July 3, 2024

**Re: McKinley Bicycle Center/ PHASE 1 Renovations
3333 Truman St. NE
30-Day Temporary Certificate of Occupancy
Transportation Development Final Inspection
Architect's Stamp dated 11-04-21 (G17-D091)
Certification dated 06-27-24**

A1 TRANSPORTATION CIRCULATION LAYOUT  
1" = 20'-0"

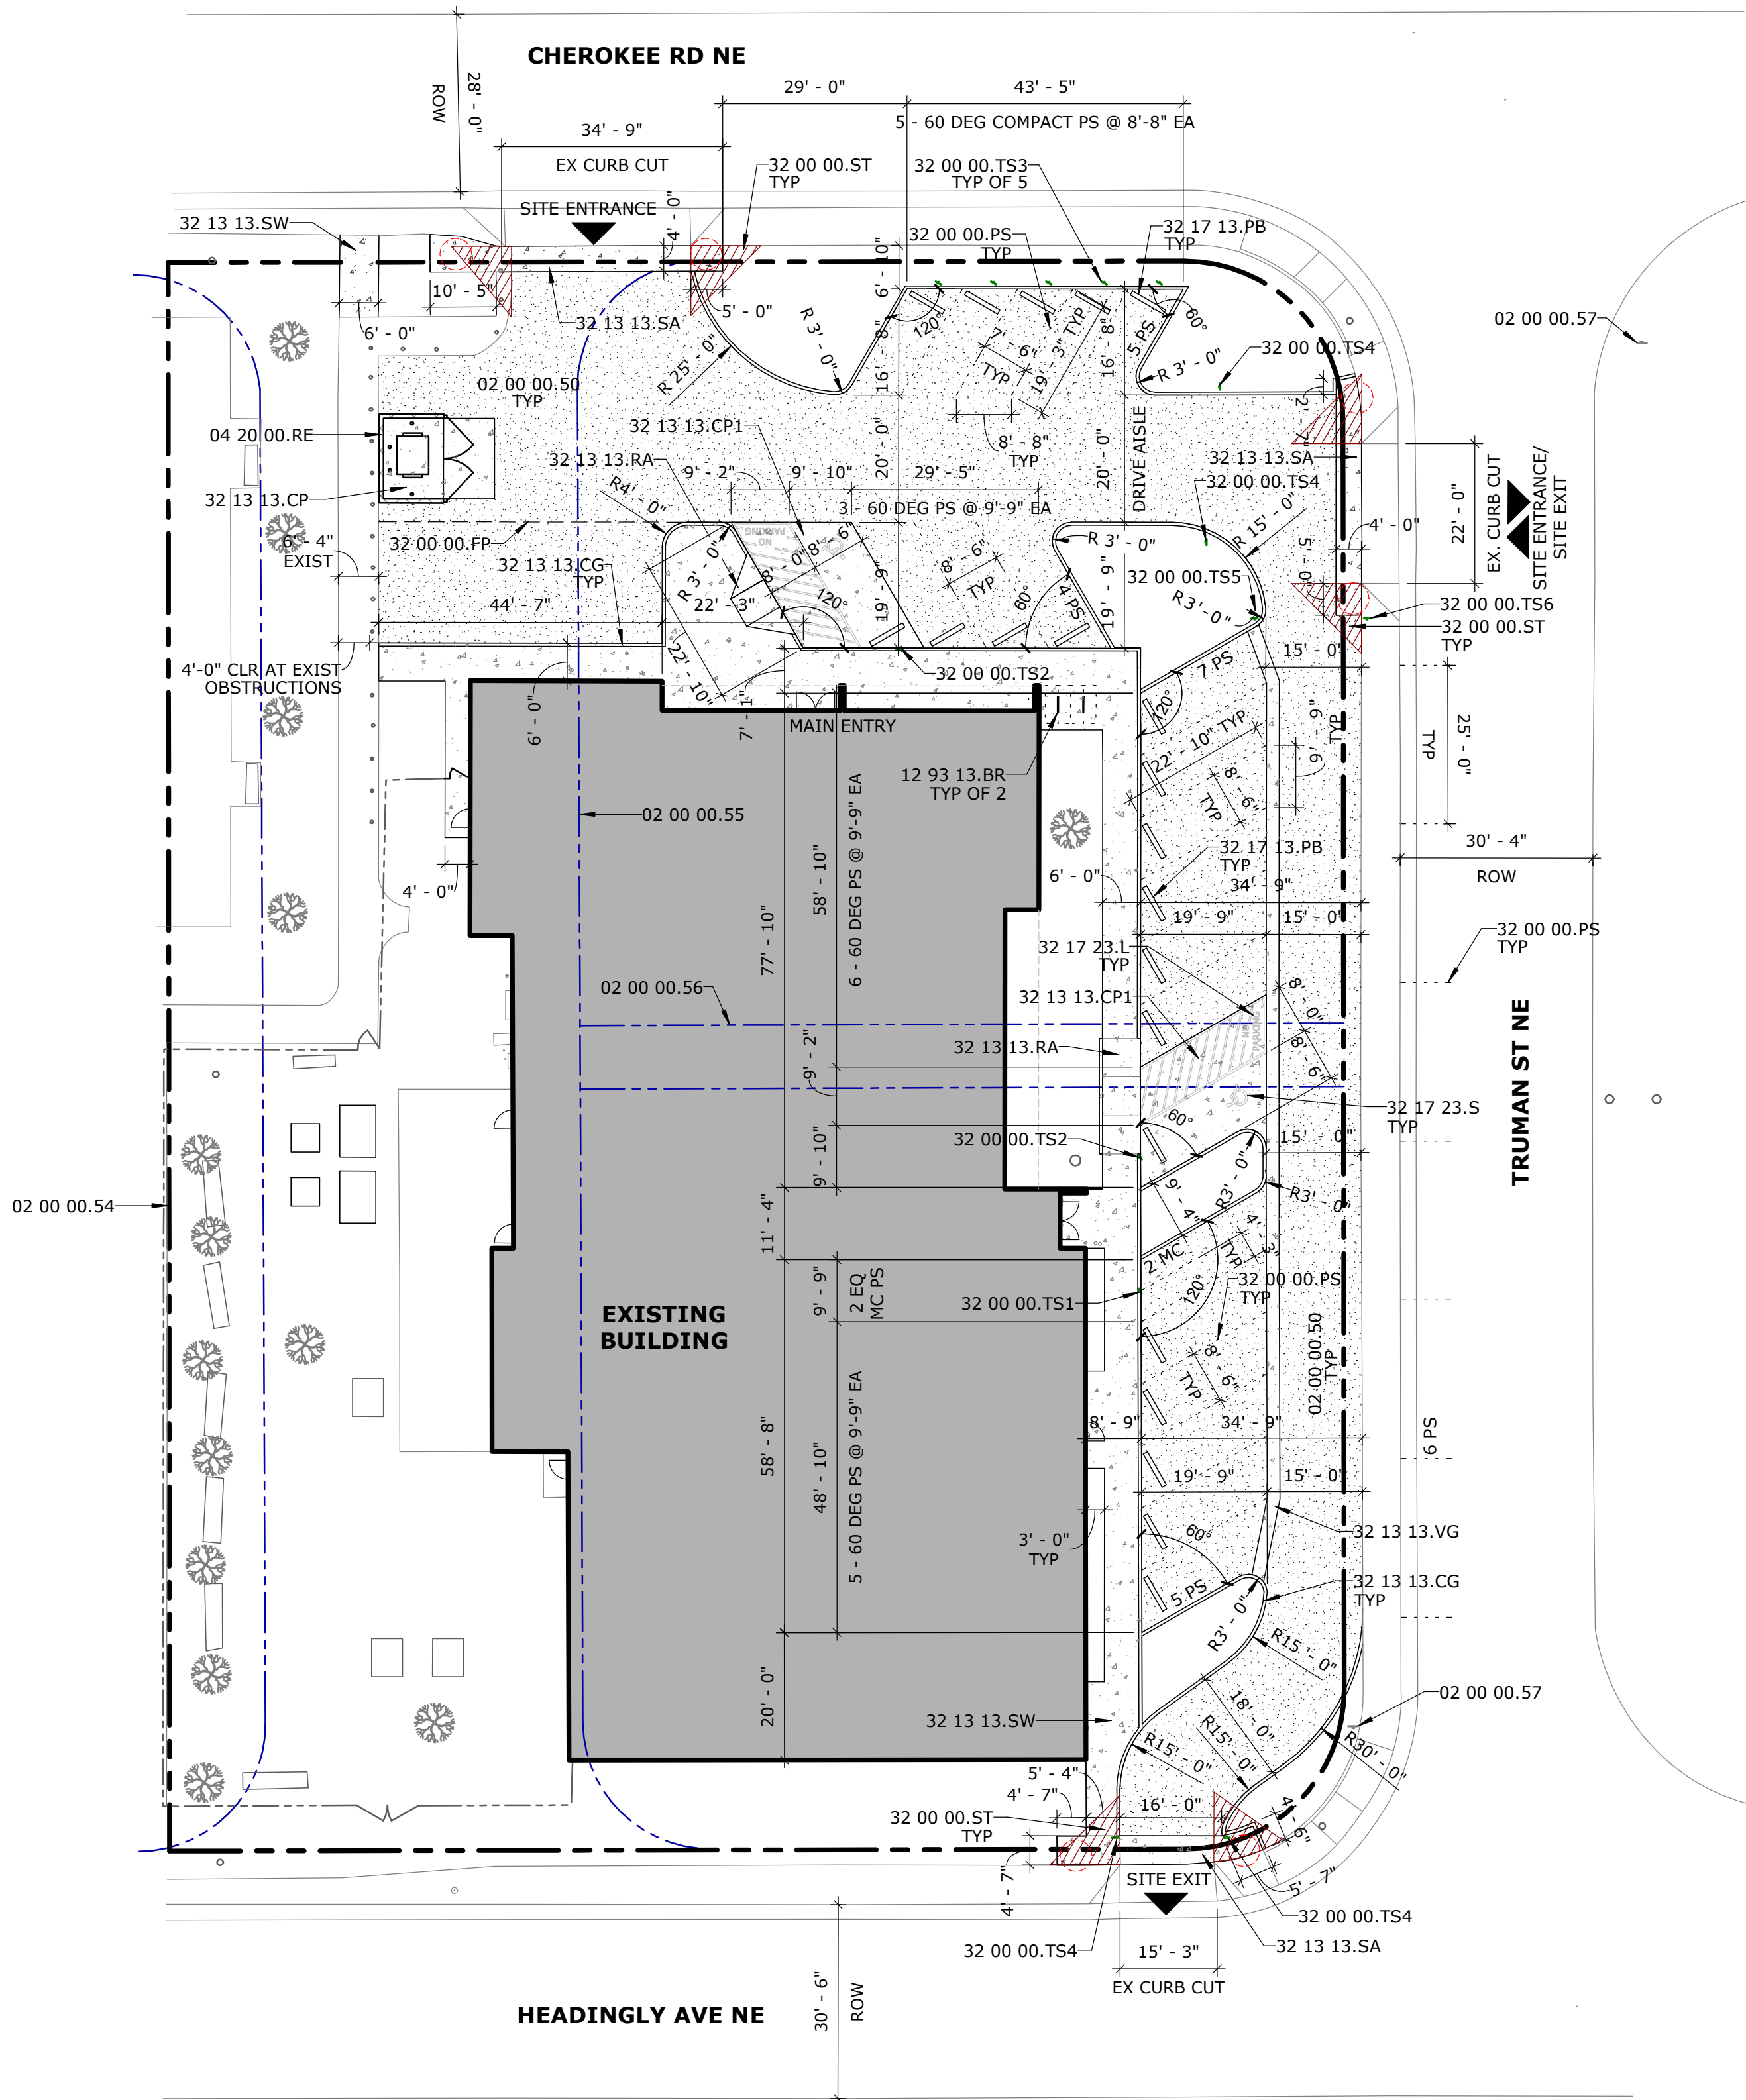
- The ADA pathway from the public sidewalk to the building entrance must be accessible. Please remove the fence from this area to ensure compliance.
